Our Ref: FG/209/21/DOC

**Approval of details reserved by condition imposed under ref APP/C3810/W/3269319 (FG/123/20/PL) relating to Condition Nos 3 - external paint colour of storage containers and 5 - fire hydrant or stored water supply.**

**Land at former McIntyre Nursery Littlehampton Road Ferring BN12 6PG**

STATUS PLANNING		CLIENT Standby Self Storage	
SCALES 1 : 1250	DATE Oct 2017	SIZE A3	
TITLE LOCATION PLAN			
DWG NO 5320-1		REV A

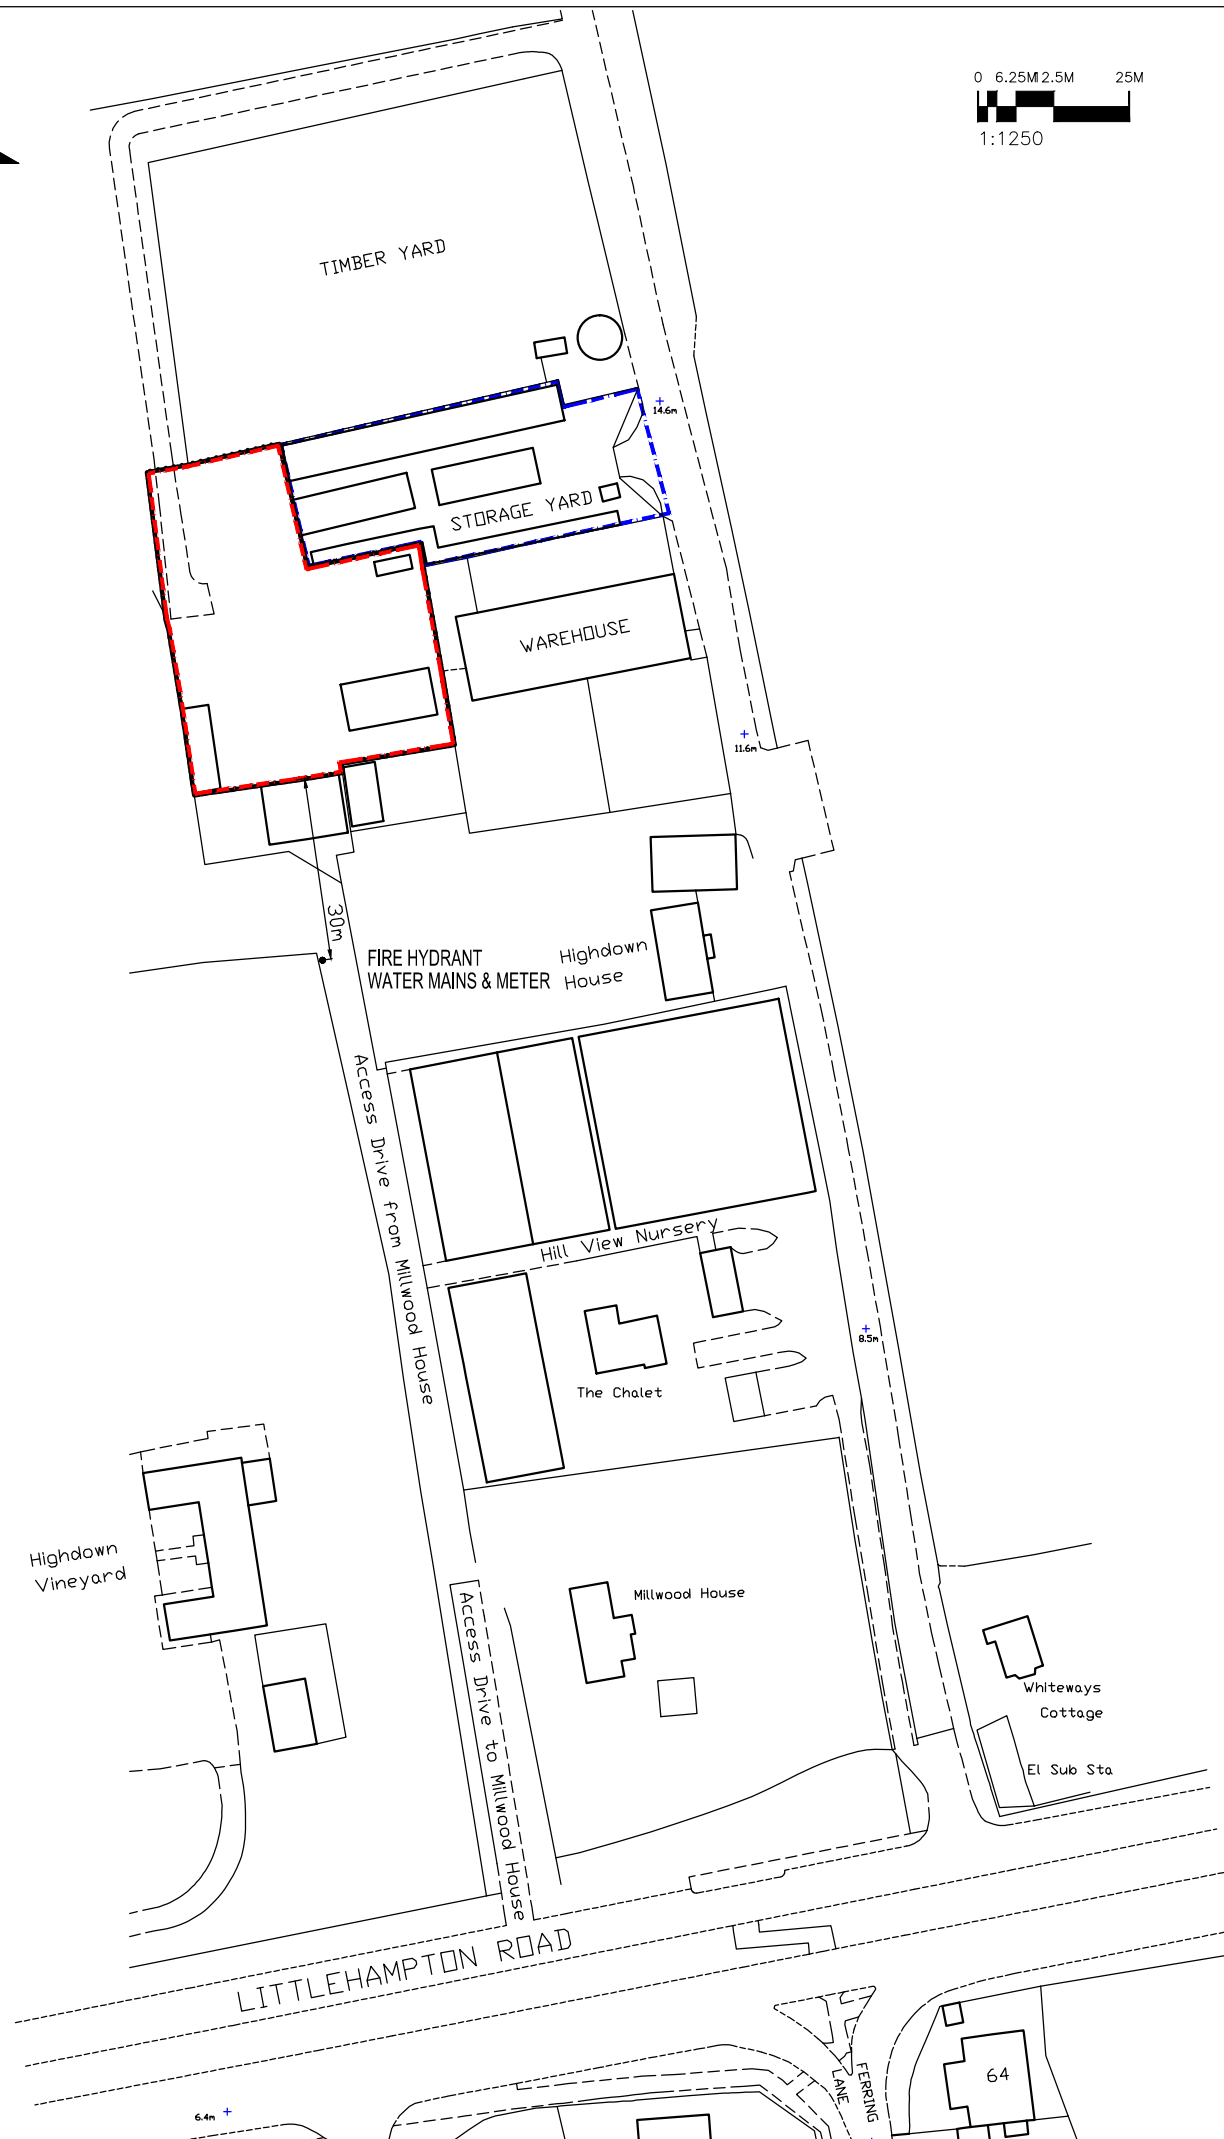
This condition is discharged in so far as submission of details relates, but you are advised that for a Private hydrant to be considered for use as a fire hydrant West Sussex Fire and Rescue Service will need to be made aware of its location and advised of the water main dimension to ensure it is 90mm or more. They would then attend the site and test the hydrant to check there is sufficient pressure, and then plot it on their water management system to inform any attending fire crews of its whereabouts. Without this information the Fire Service would not know the fire hydrant existed and available for use.
